**RE: Dutch Bros 2501 Juan Tabo Blvd. NE
Traffic Circulation Layout**

Isaacson & Arfman, acting as agents for Accelerated Development, the Developer of the above-referenced project, is applying for Traffic Control Layout for Building Permit. A conceptual TCL was previously submitted with Engineer Stamp Date 10-24-2022 and comments were provided. The following is an explanation of how those comments have been addressed.

**CP-401**

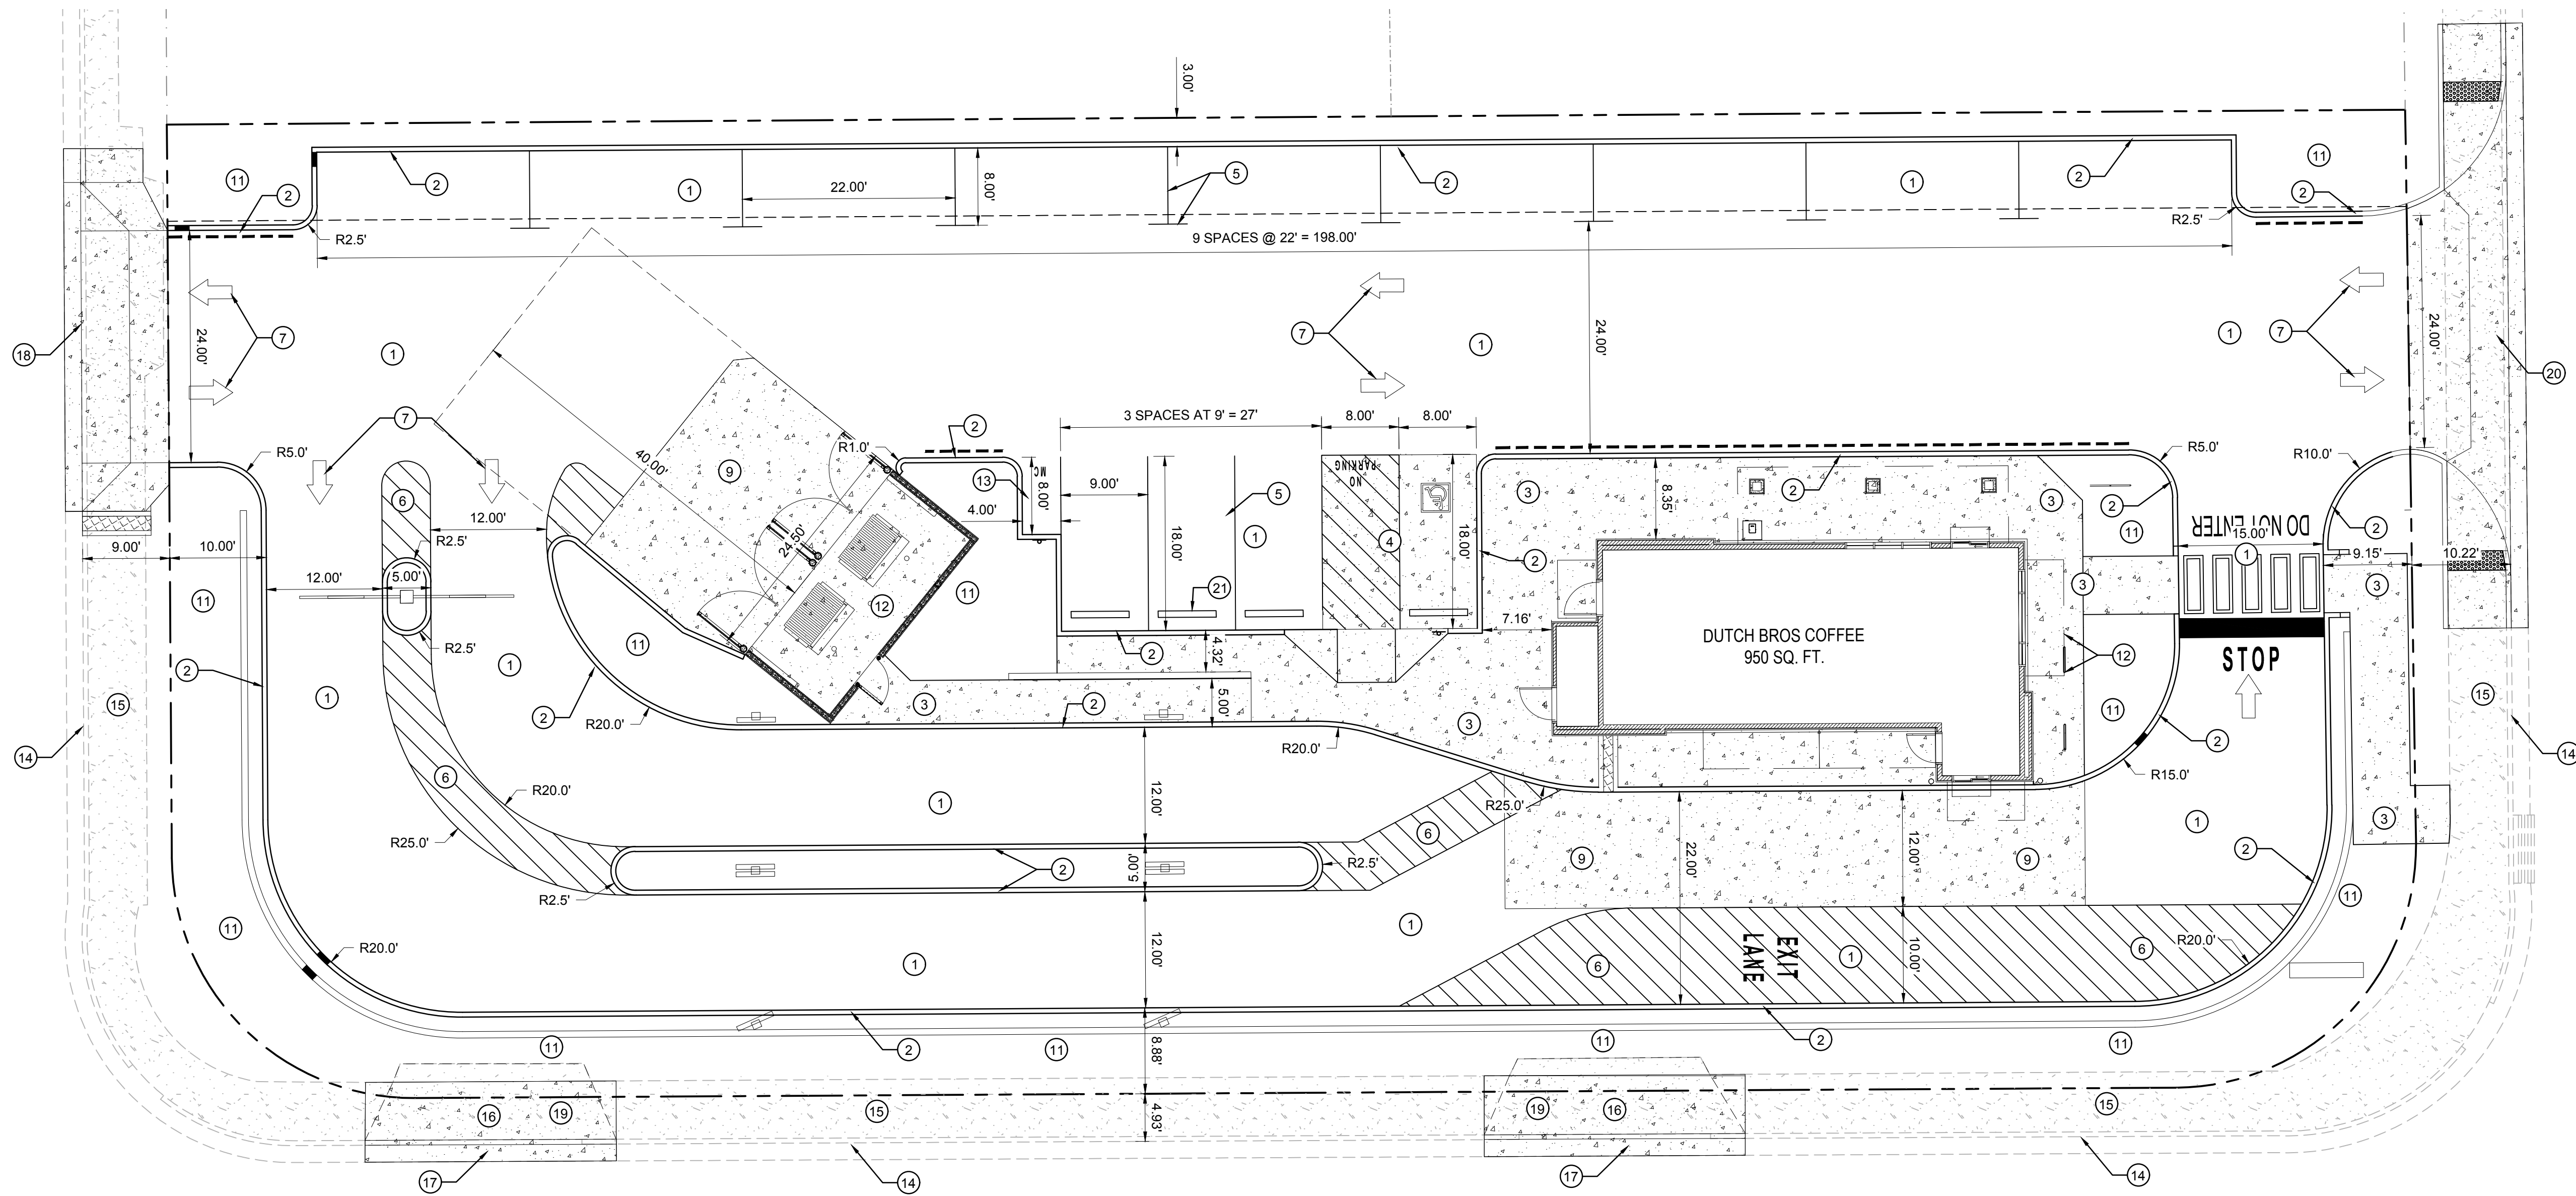
1. A vicinity map has been added to the plan.
2. Additional dimensions and notes have been added to the plan.
3. Per our phone conversation the 150' requirement does not apply. I am attaching a PDF of the plat for the property. Property line labels have also been added to the plan. In addition, Accelerated Development Services had a call with Jeanne Wolfenbarger in May and discussed the conceptual site plan for the above referenced property. Jeanne later approved the proposed access point location and configuration on Juan Tabo and Muriel as designed. Ernest Armijo indicated that he did not have a problem with the access on Juan Tabo Blvd as long as Jeanne had already approved this access point. Enclosed is the e-mail correspondence from Jeanne and Ernest. The dimensions for the access on Juan Tabo are now depicted on the site plan.

4. Radii dimensions added to Juan Tabo entrance.
5. See response 3 above.
6. The ADA space has been modified to be 8.5' wide.
7. The entry along Muriel is existing and we are proposing to modify it to comply with COA STD DWG 2425A per direction from Ernest Armijo. Keyed notes have been added to the plan.

SIGN TYPE DBDIR-DT-DF: NON-ILLUMINATED D/F DIRECTIONAL

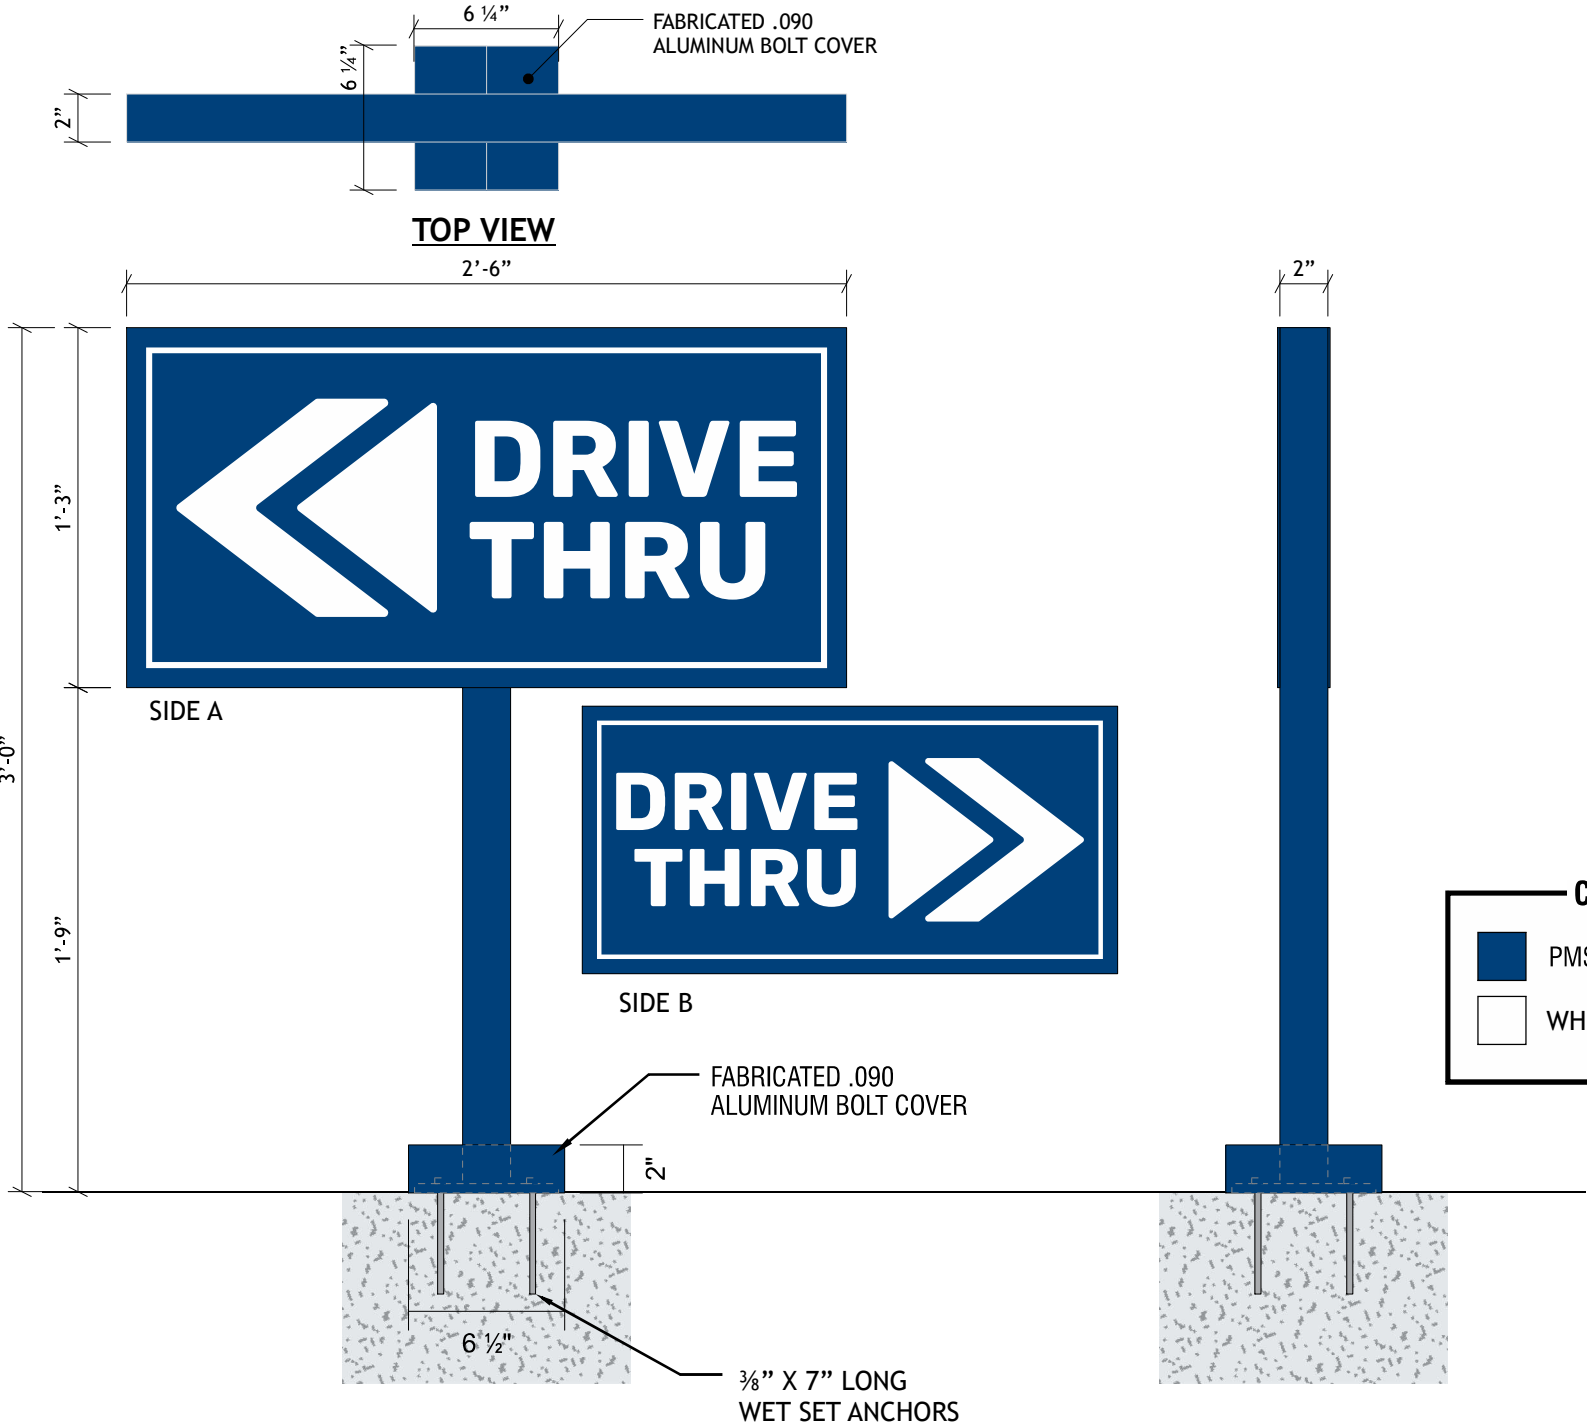
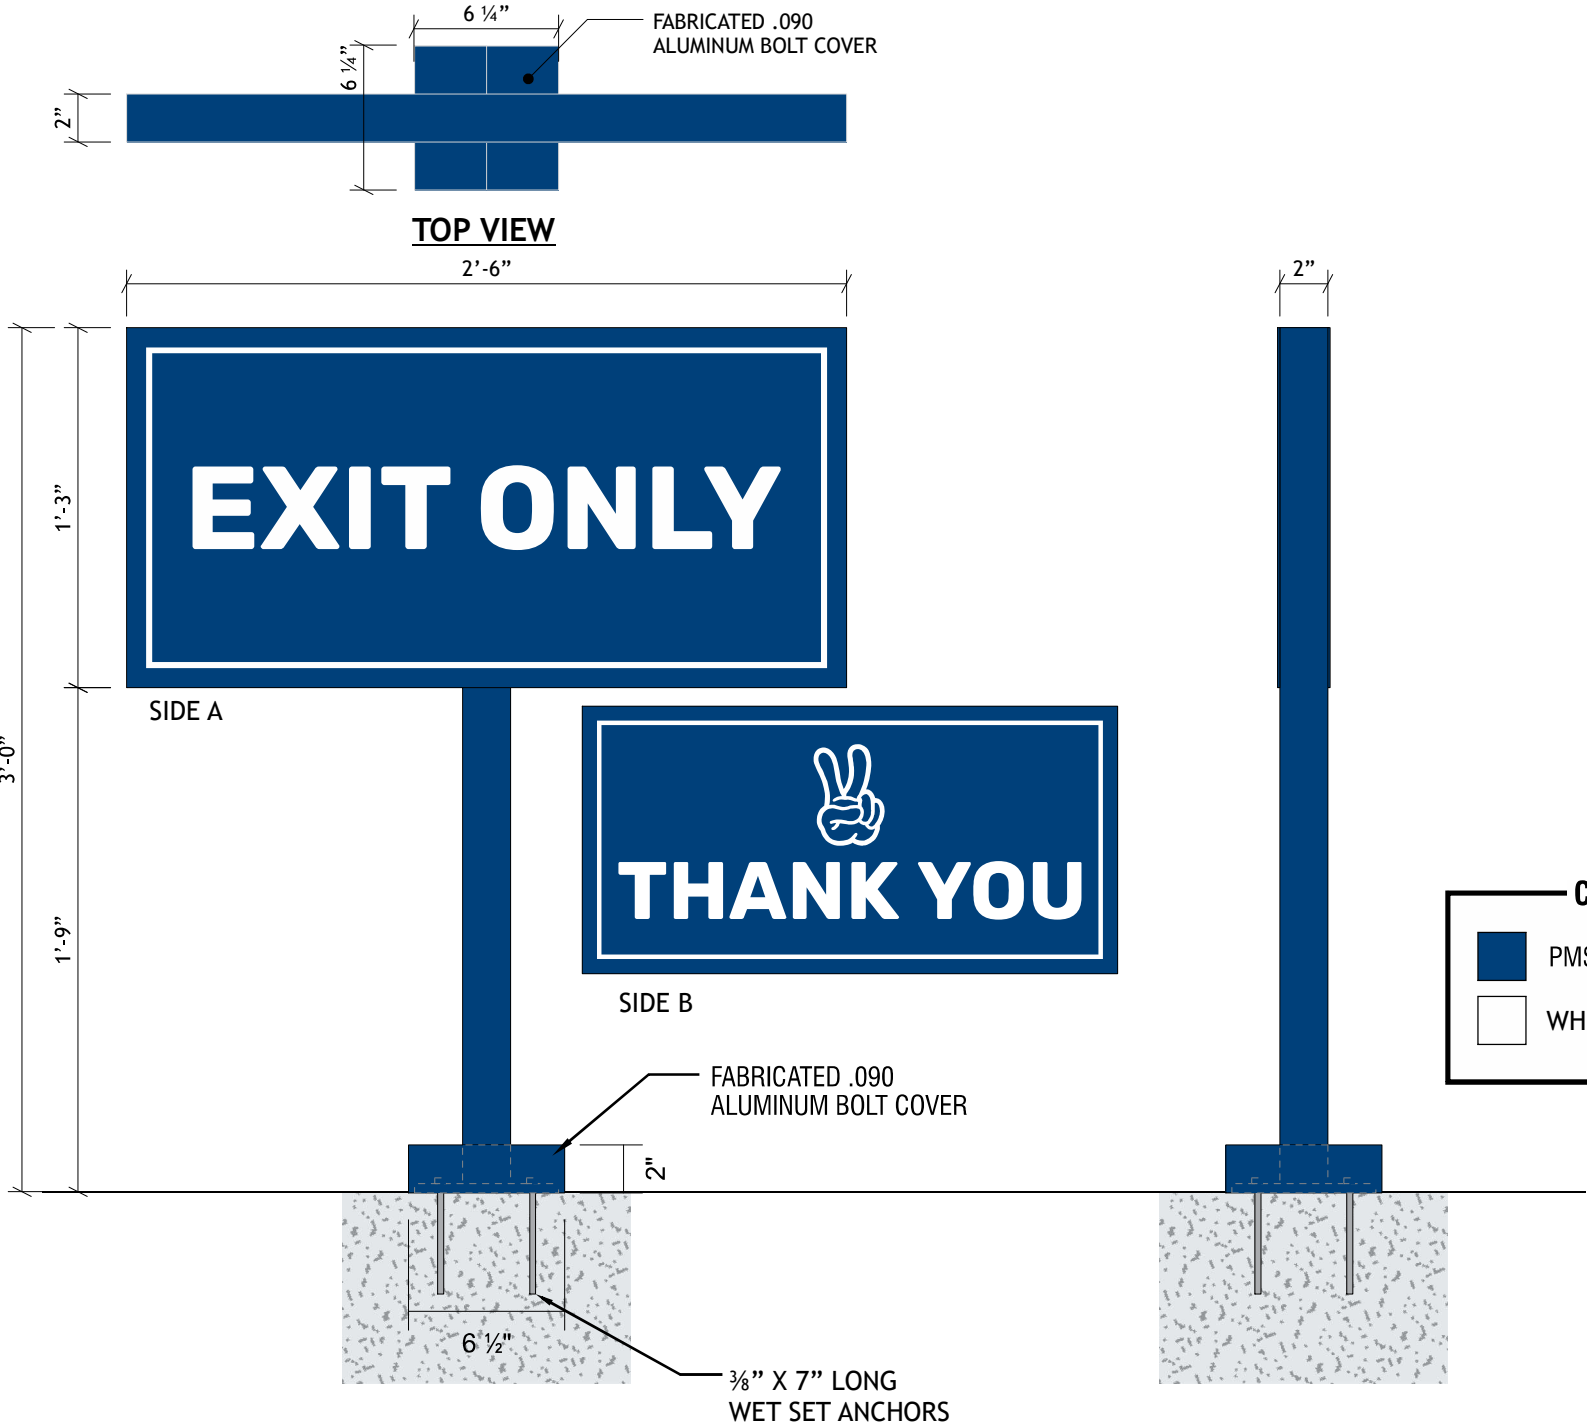
18. Approved Fire 1 included in attachments.
19. Site signage details have been included. These signs have been used on other Dutch Bros projects in Albuquerque.
20. A sight distance exhibit is included.
21. Clear sight triangles have been added to the plan.
22. The plan has been updated to include COA STD DWG numbers.
23. The plan has been revised to address this item.
24. <this letter>
25. Completed Traffic Scoping Form in attachments.

Herman Gallegos *Herman Gallegos* 11-17-22  
**SOLID WASTE APPROVAL DATE**

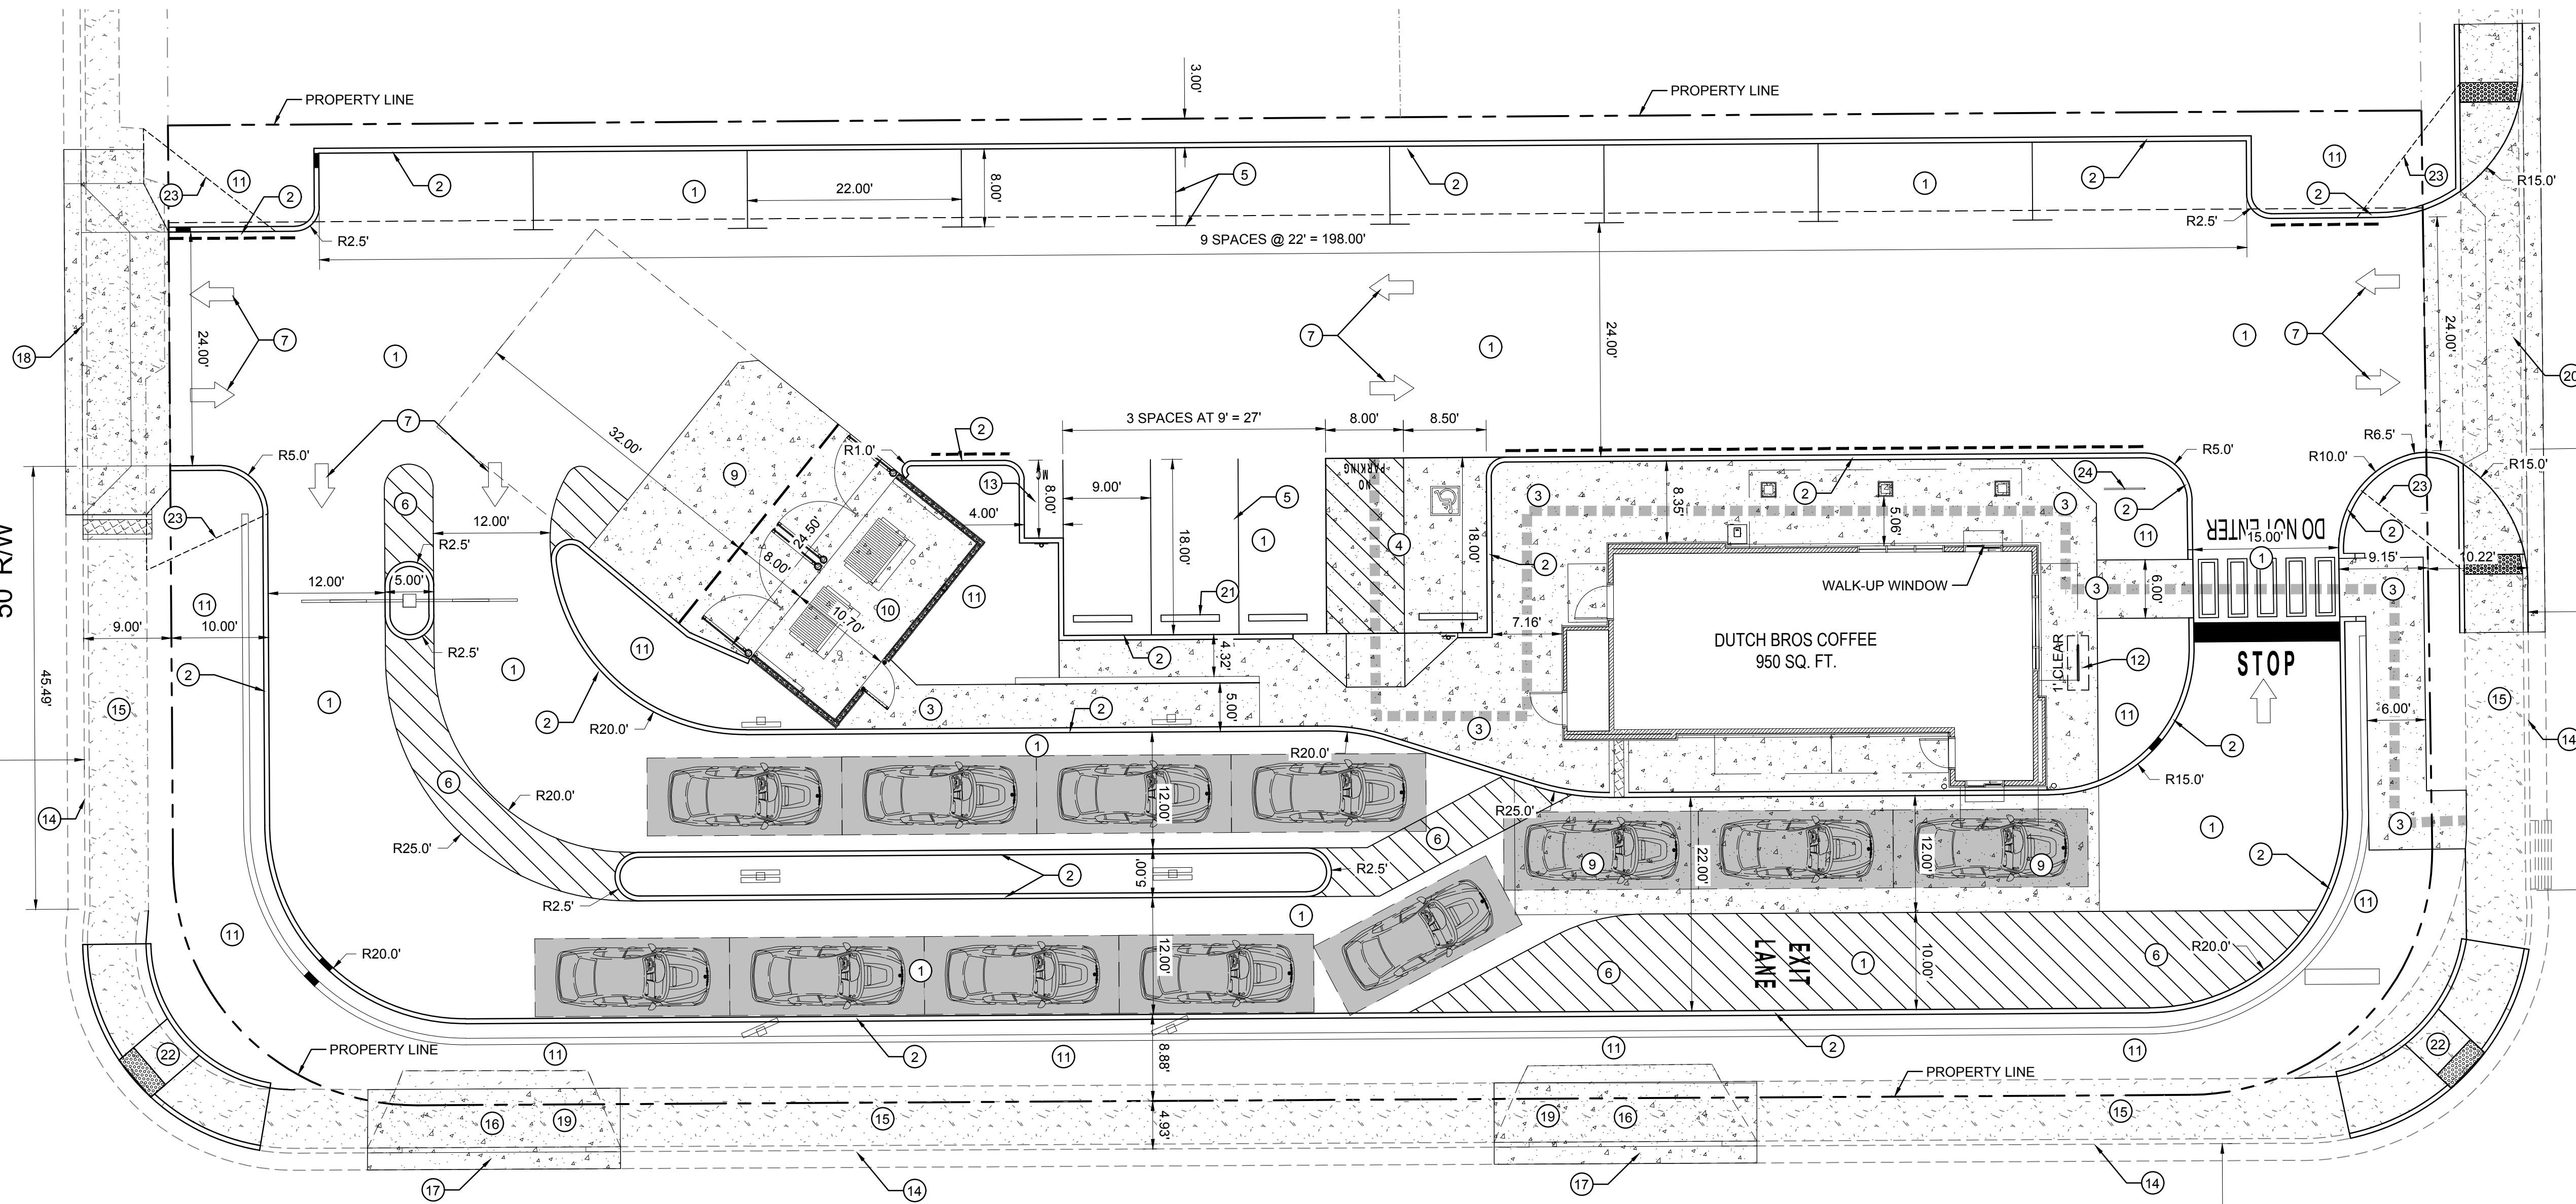
16. See response 15.
17. Solid Waste signature has been added to the plan.
